PUBLIC SUBMISSIONS

Shadows

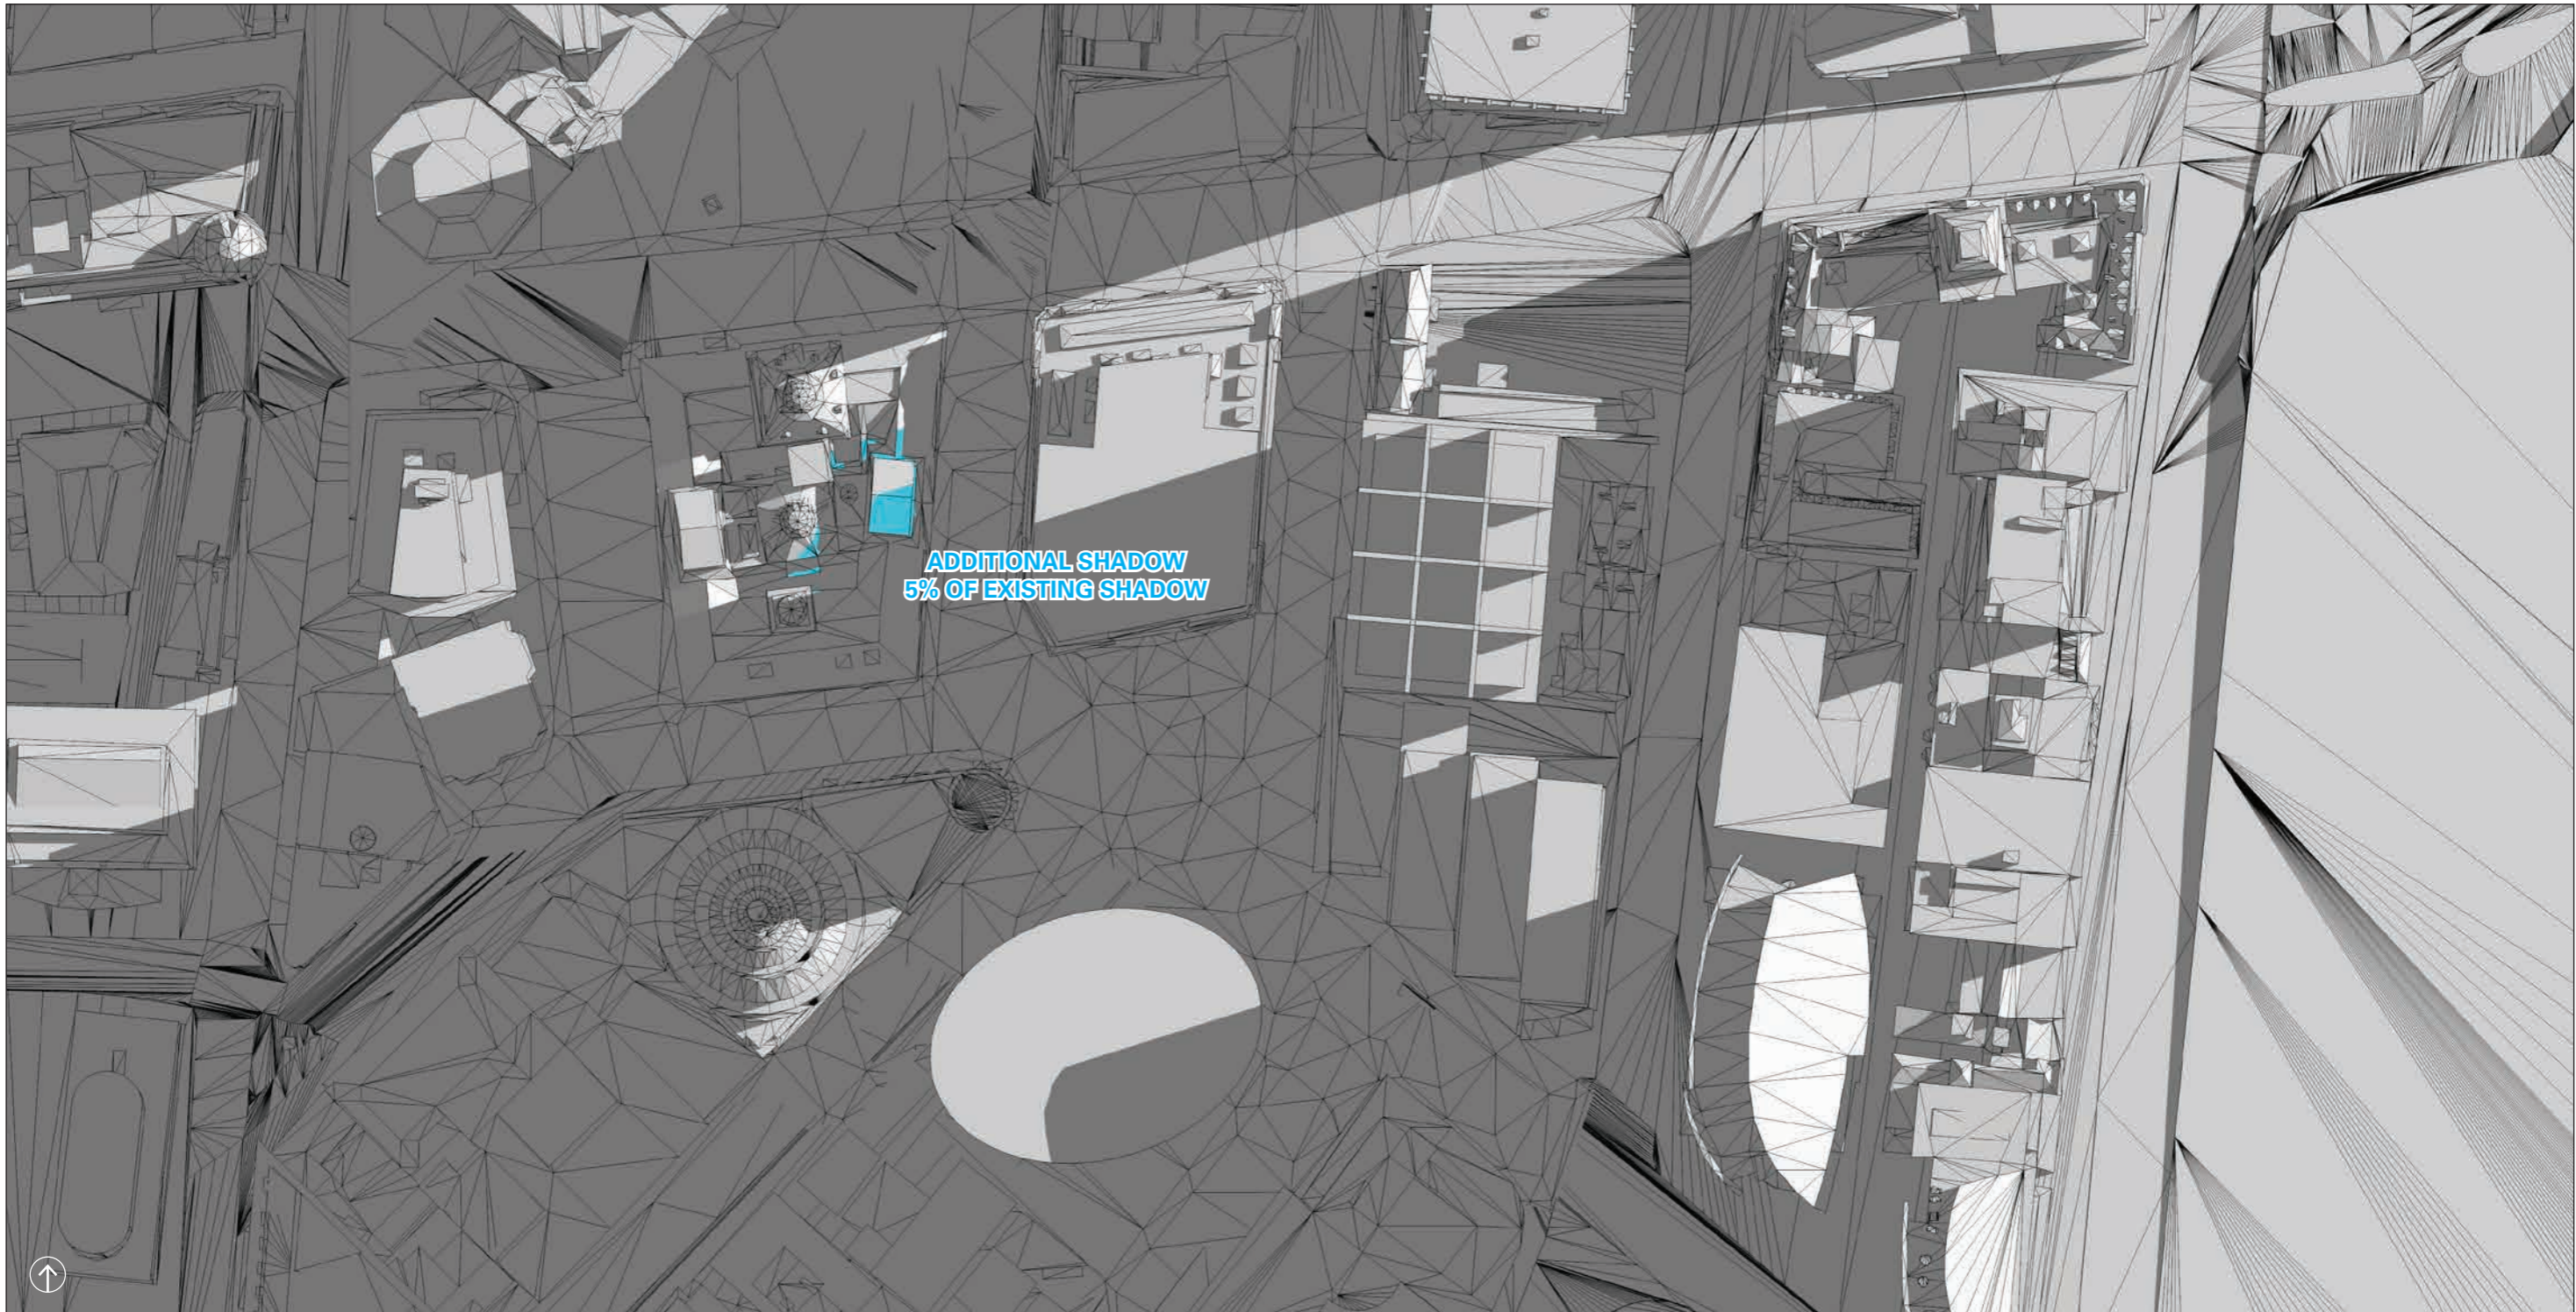
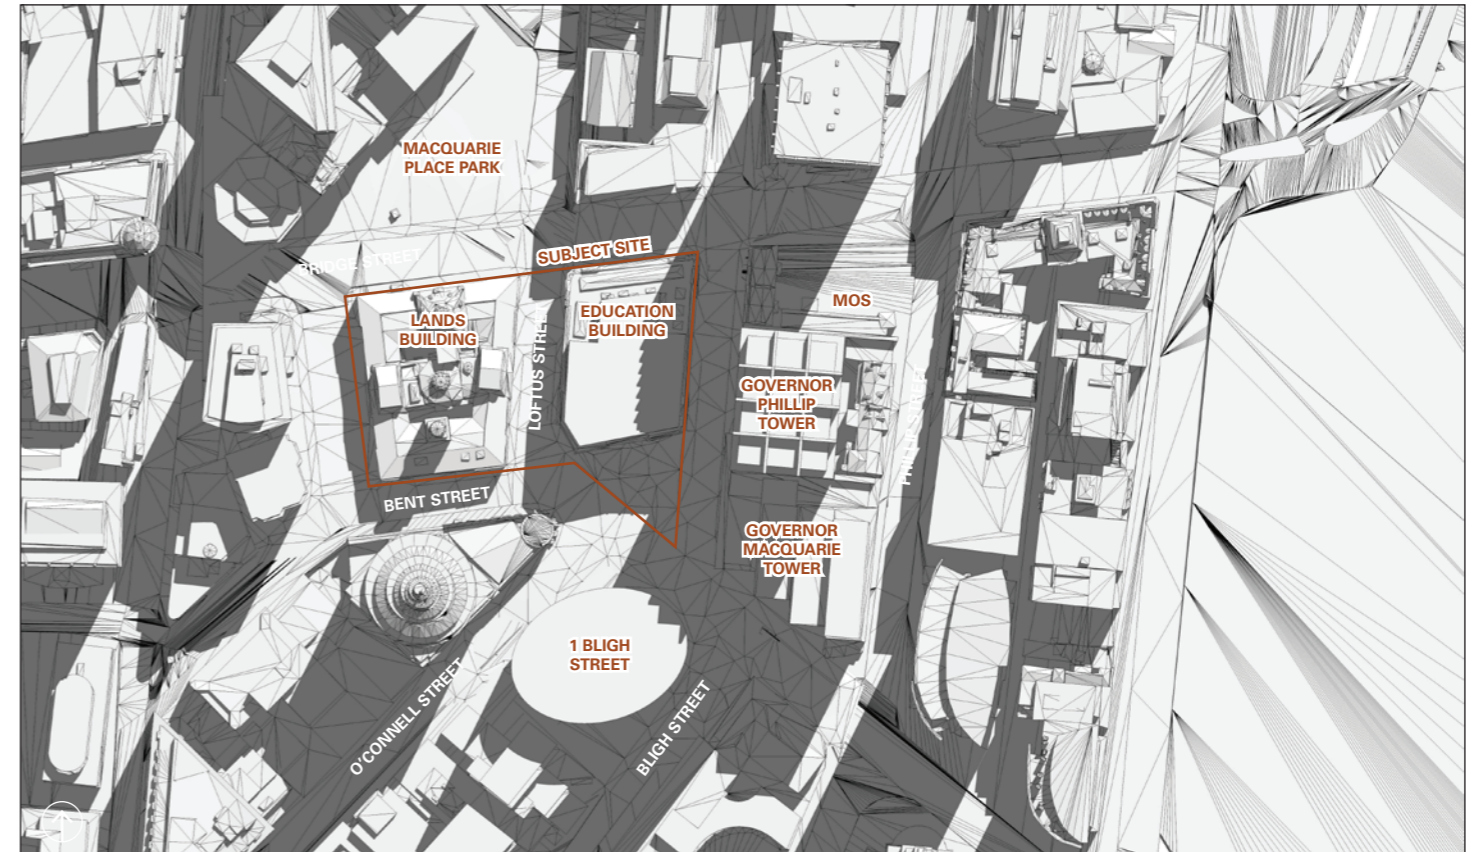
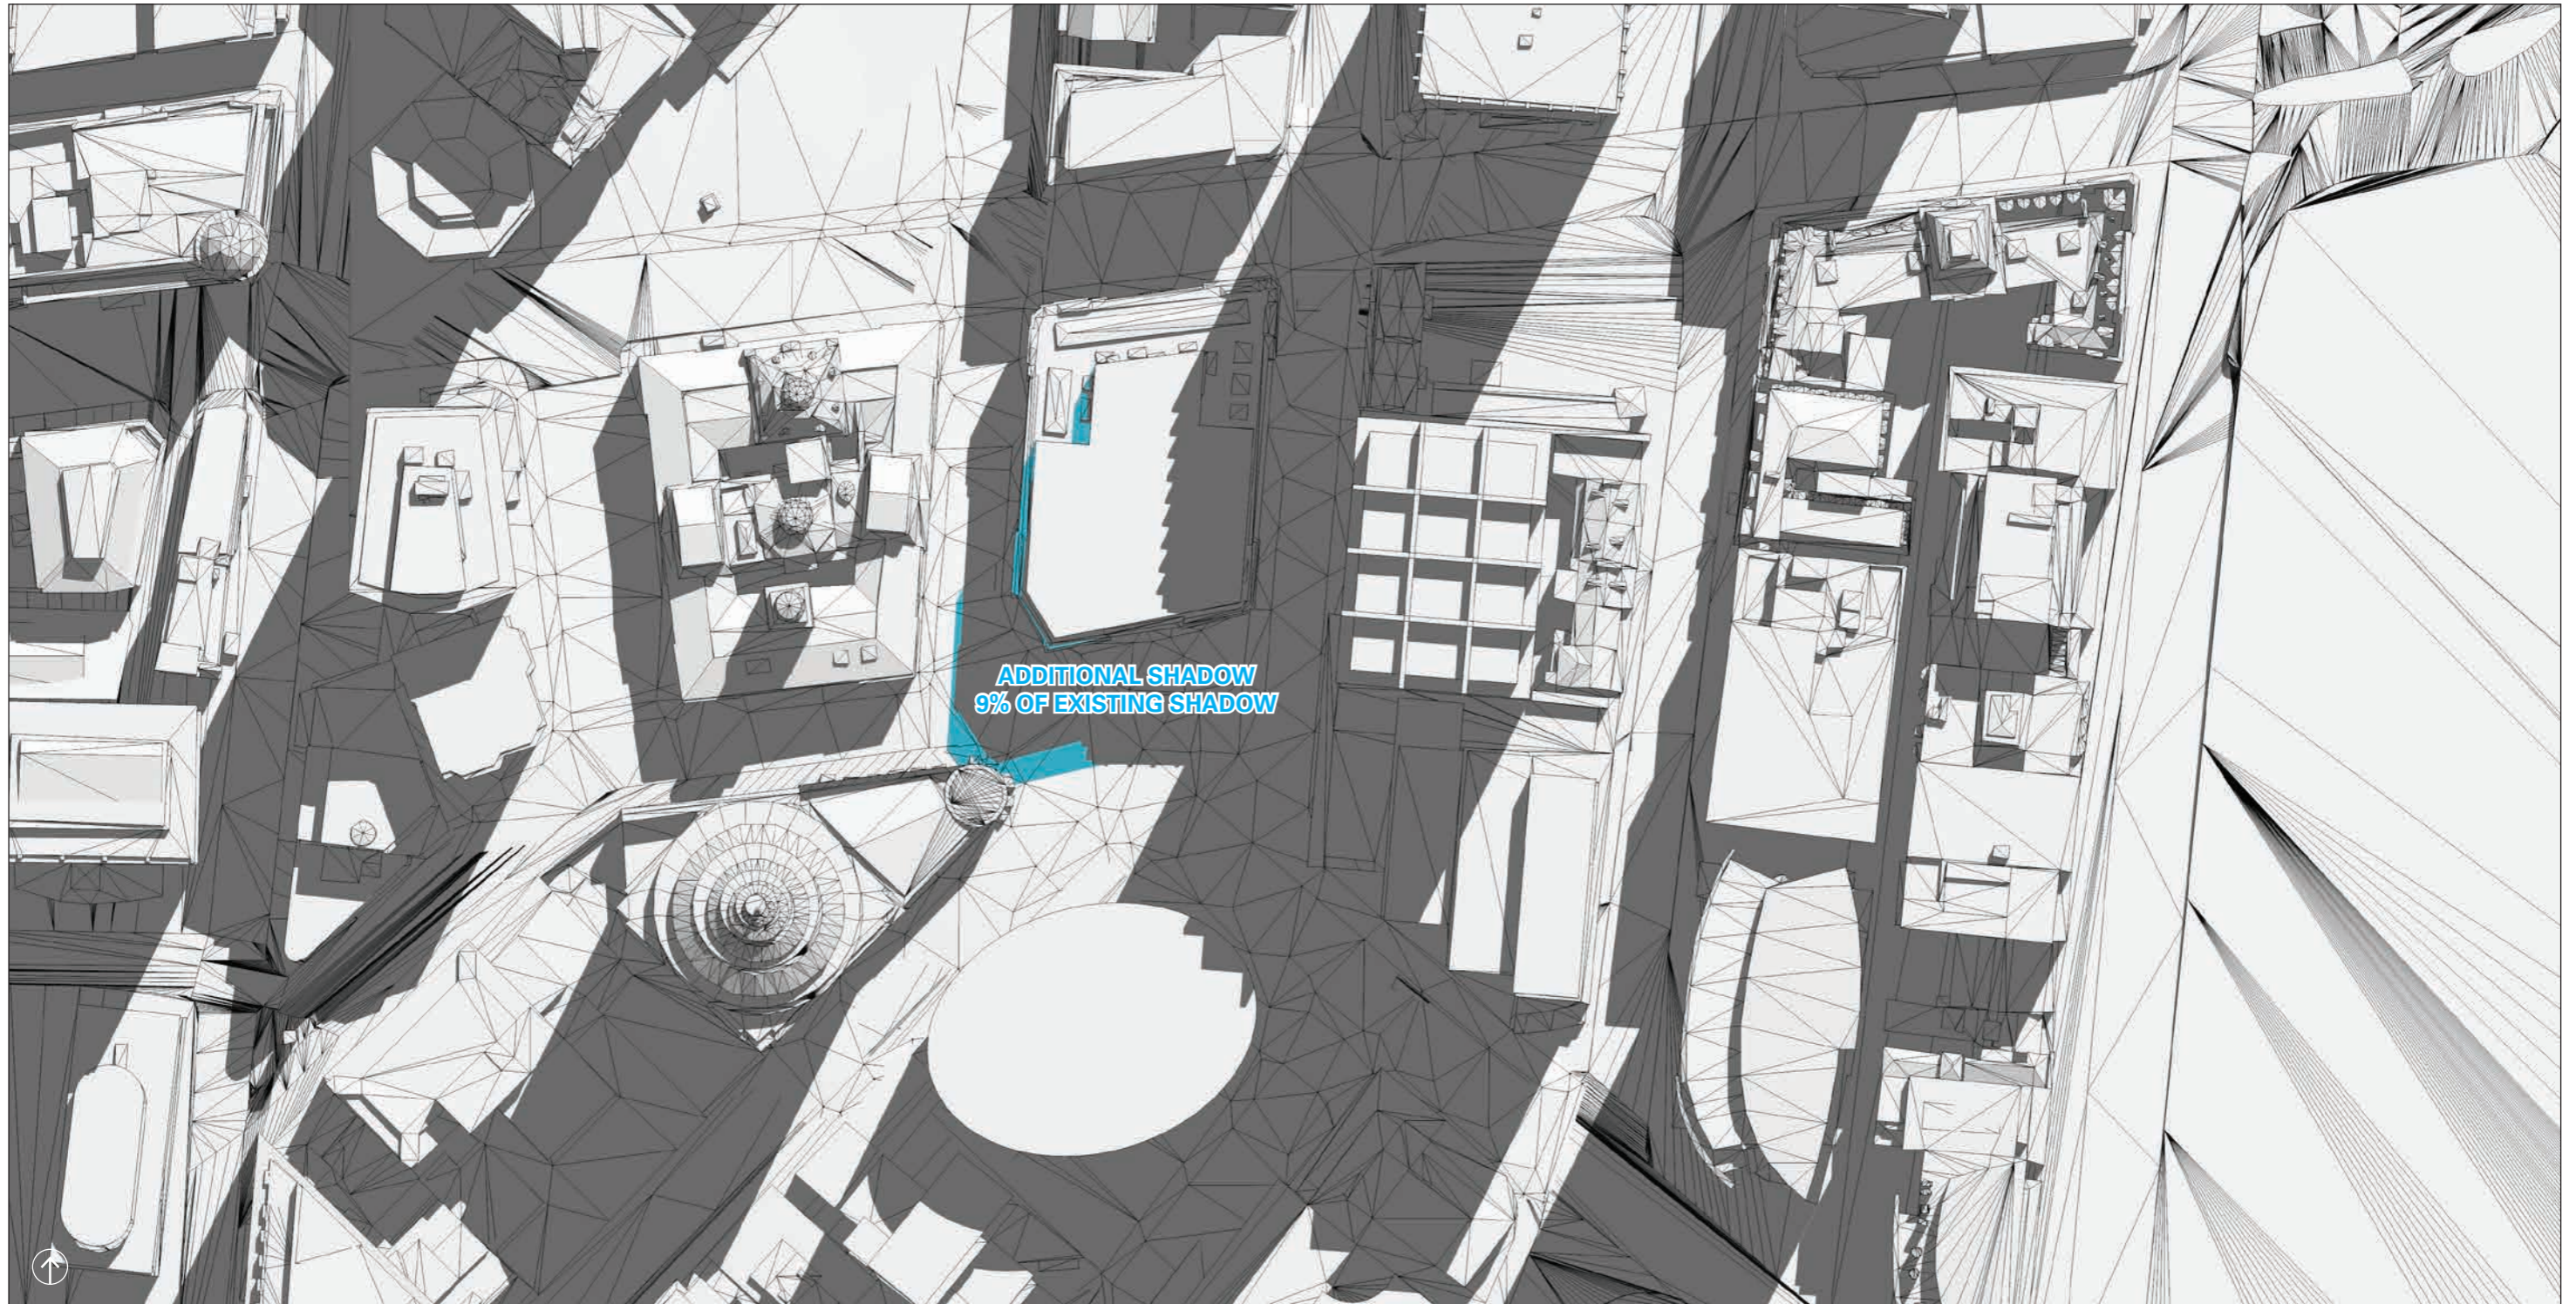
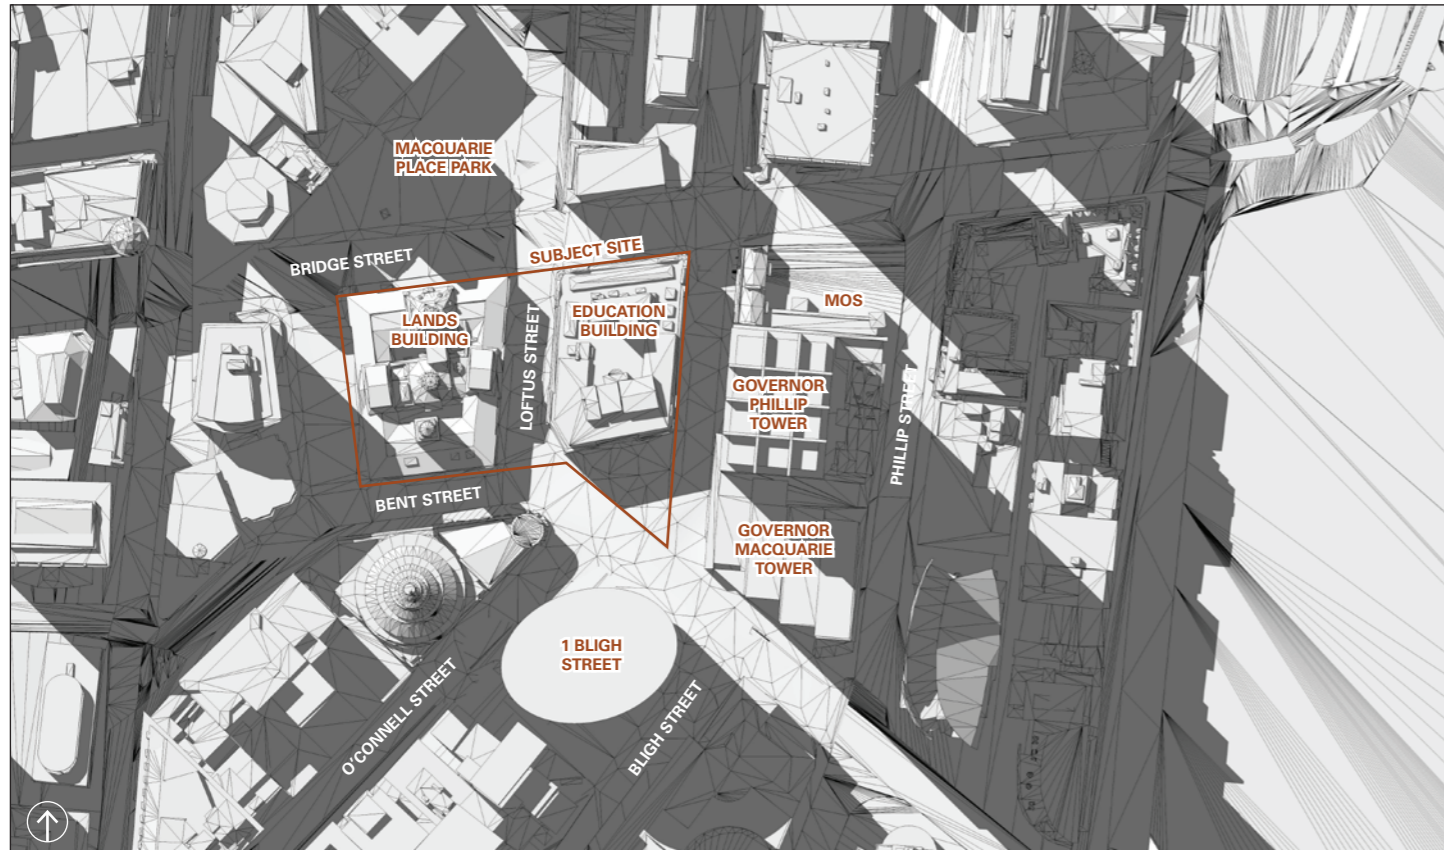
| <p>HEIGHT/OVERSHADOWING</p> <p>Increase in overshadowing</p> <p>Height increase is unacceptable when viewed from adjoining streets (should be setback)</p> <p>Rooftop additions should be setback</p> <p>The additional floors which create unacceptable shadow impacts on Farrer Place.</p> <p>The additional floors will create overshadowing on the Lands Building, which has not been addressed.</p> | <p>6</p> | <p>Clive Gunton</p> <p>Philip Drew</p> <p>WITHHELD</p> <p>WITHHELD</p> <p>John Freeman</p> <p>Peter Webber</p> | <p>See Section 2.1 of the Response to Submissions (RTS).</p> |
